**MAJOR PROJECT ASSESSMENT:
157 Redfern Street, Redfern
(MP09_0039 MOD 2)**

Director-General's
Environmental Assessment Report
Section 75W of the
Environmental Planning and Assessment Act 1979

November 2011

1.0 DA Approved L13
NTS

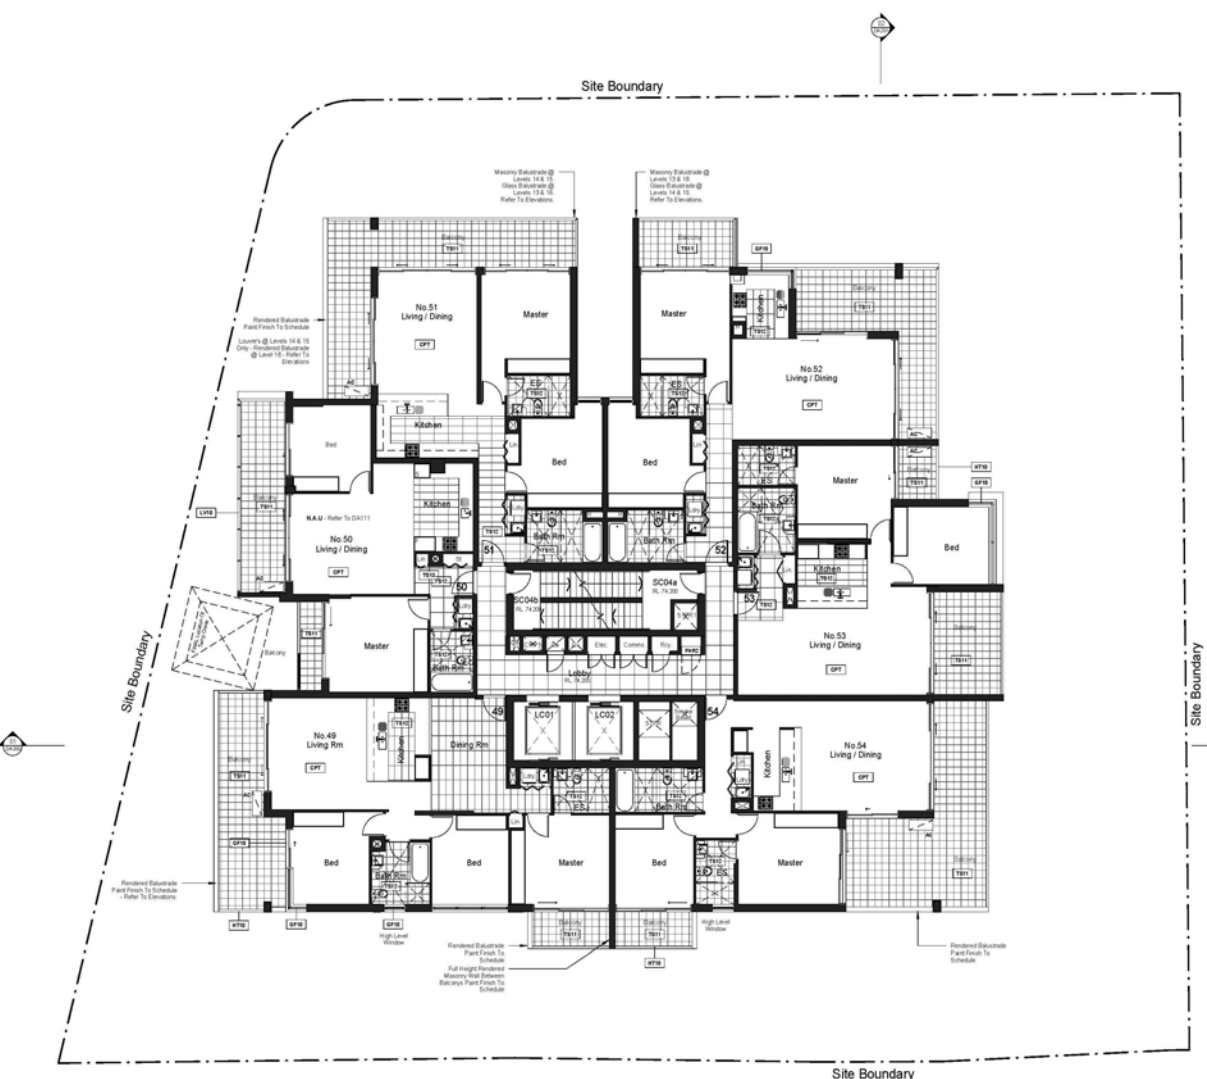
The original approval included a 3 bedroom apartment on level 13. The modification seeks approval to replace it with 2 x 1 bedroom apartments (**Figure 3**) to satisfy market demand. This will increase the number of apartments in the building to 89.

- it is consistent with the approved conversion of the corresponding 3 bedroom units to 2 x 1 bed units on levels 14 to 17 (Modification No. 1);
- the provision of car parking will be adequate because the parking rate for 3 bed units is more than twice that for 1 bed units;
- it will not result in any significant change to the external appearance of the building; and
- it will have negligible environmental consequences.

Mall Link Plan (Combined)

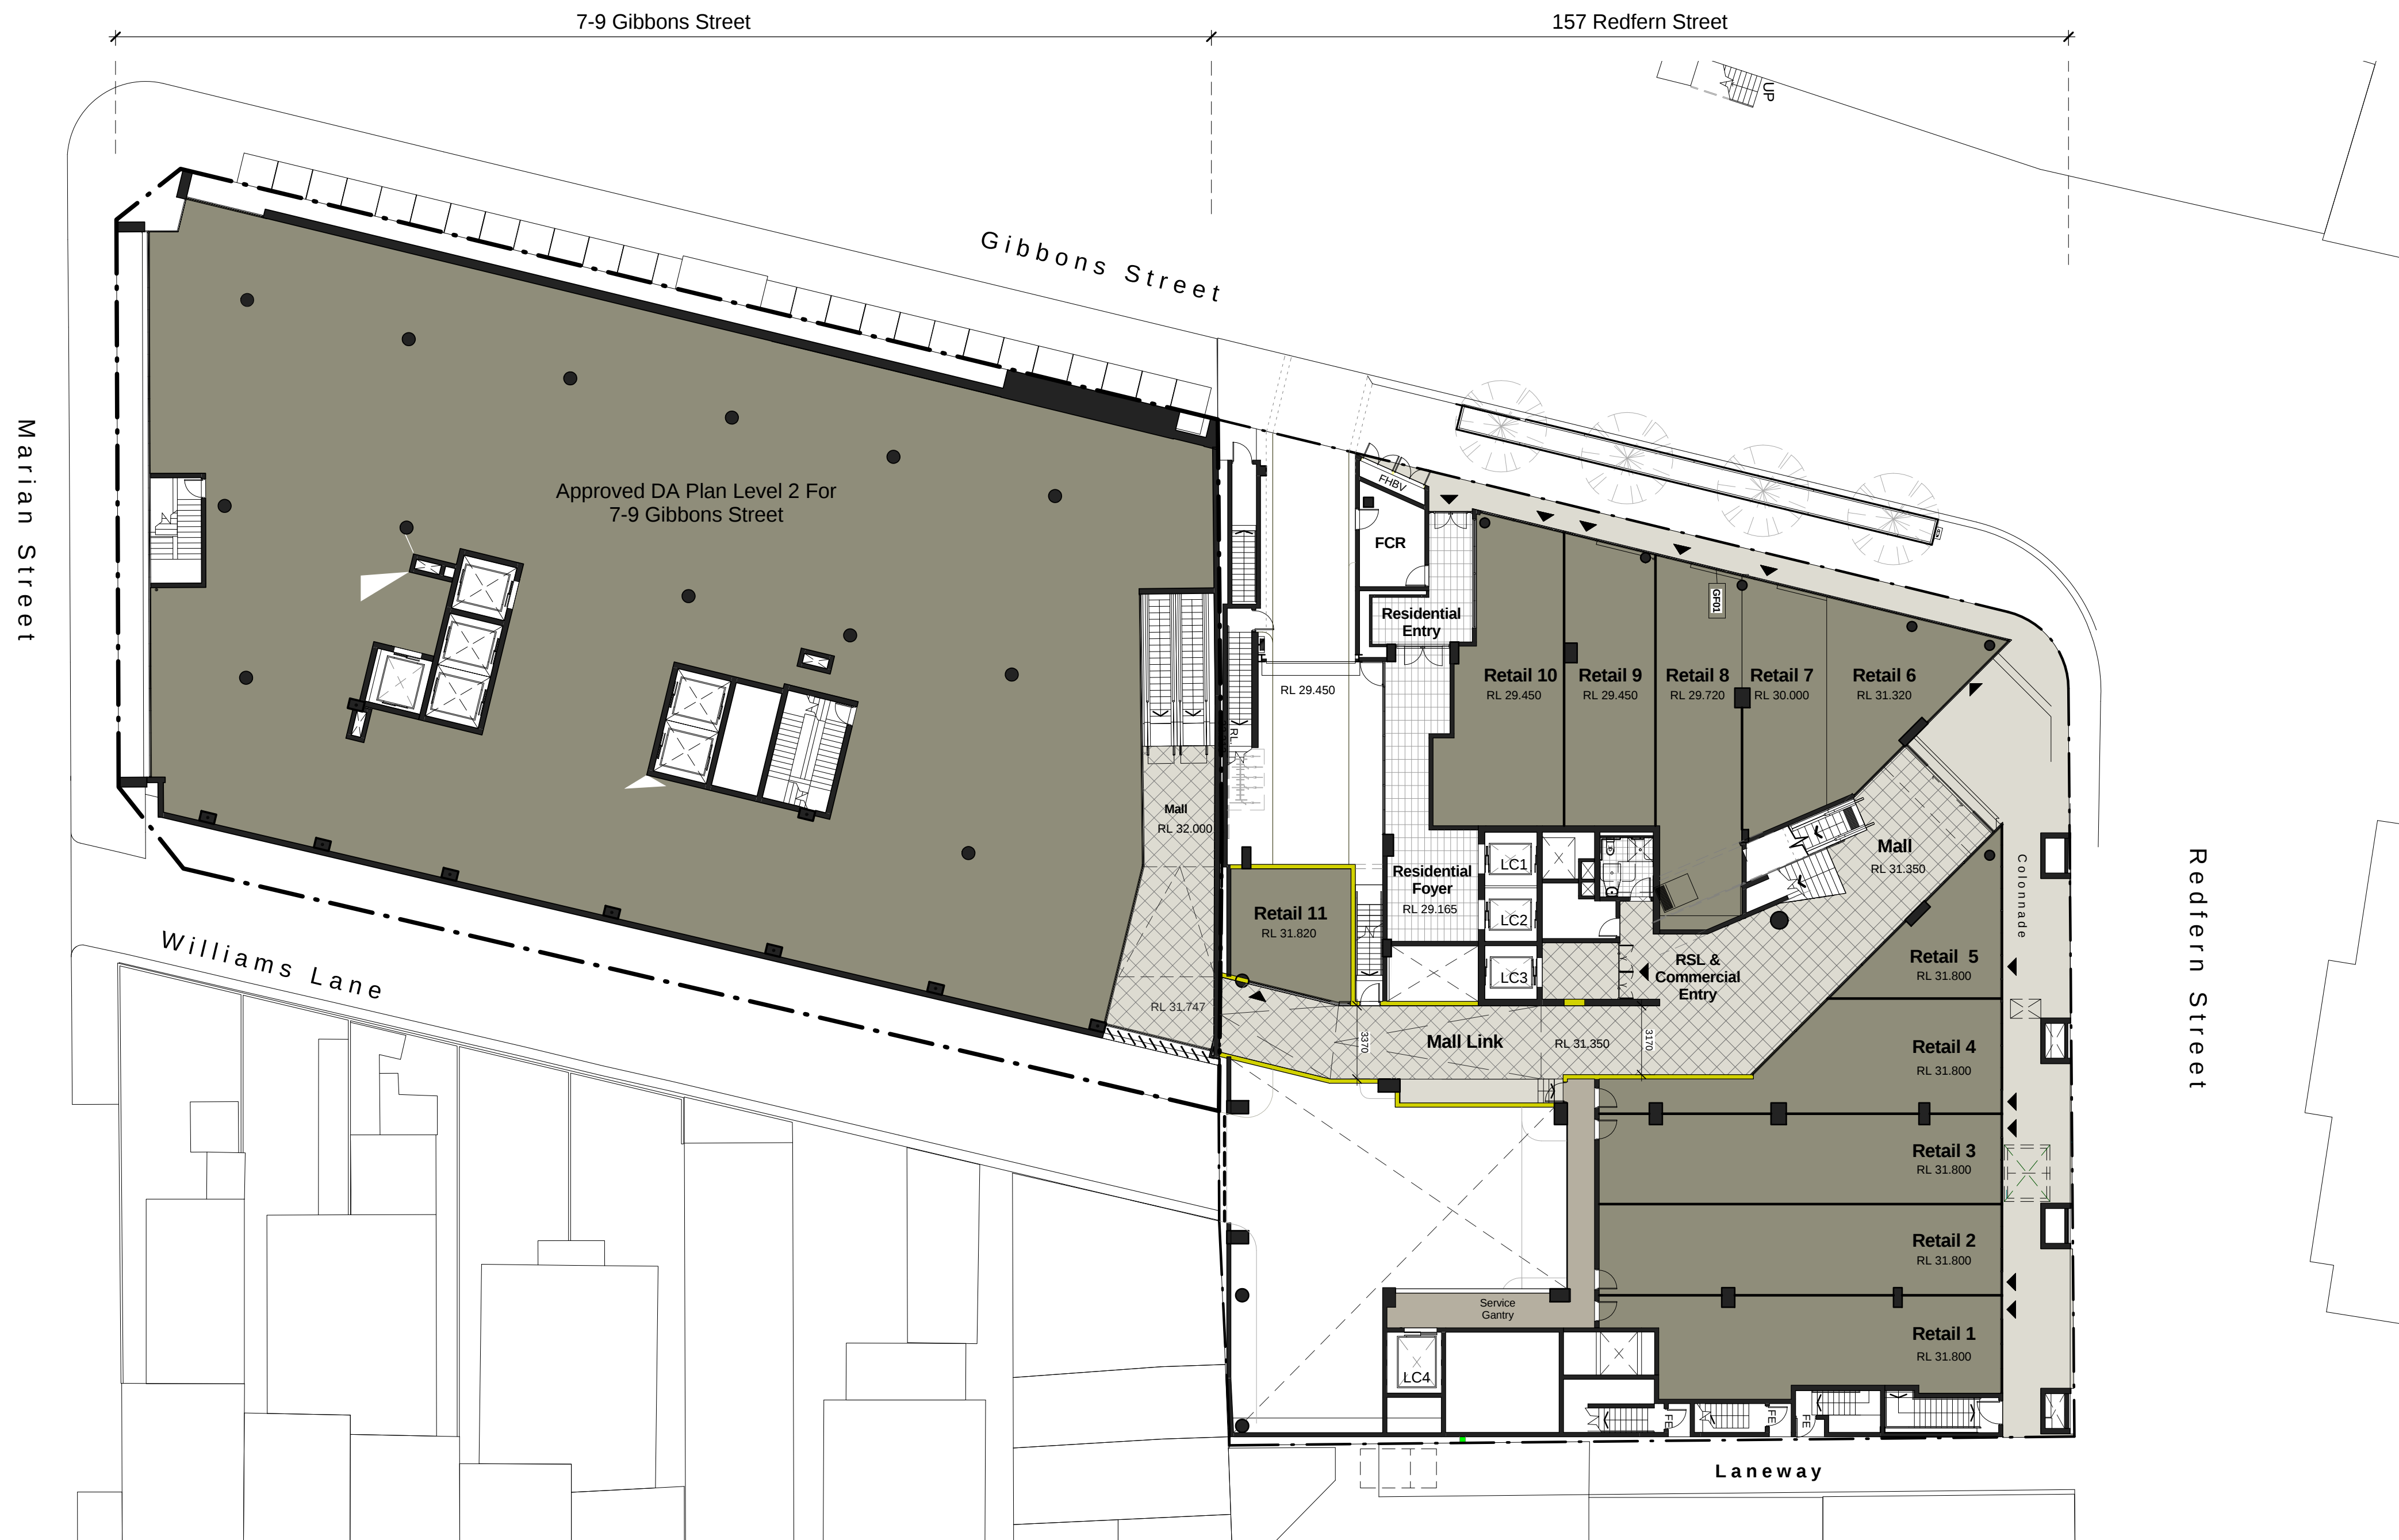
It is proposed to reduce part of a ground floor retail tenancy by 31m² and create a new 31m² retail tenancy at the end of an extended pedestrian access (mall link) to the site's southern boundary (see **Figure 2**). This will connect Redfern Street to a proposed supermarket on the corresponding level of the adjoining development at 7 - 9 Gibbons Street.

- there will be no net increase in retail floor space and therefore negligible impacts;
- a pedestrian link will be provided through the site; and
- the approved and new retail tenancies will provide opportunities for passive surveillance of the mall link.
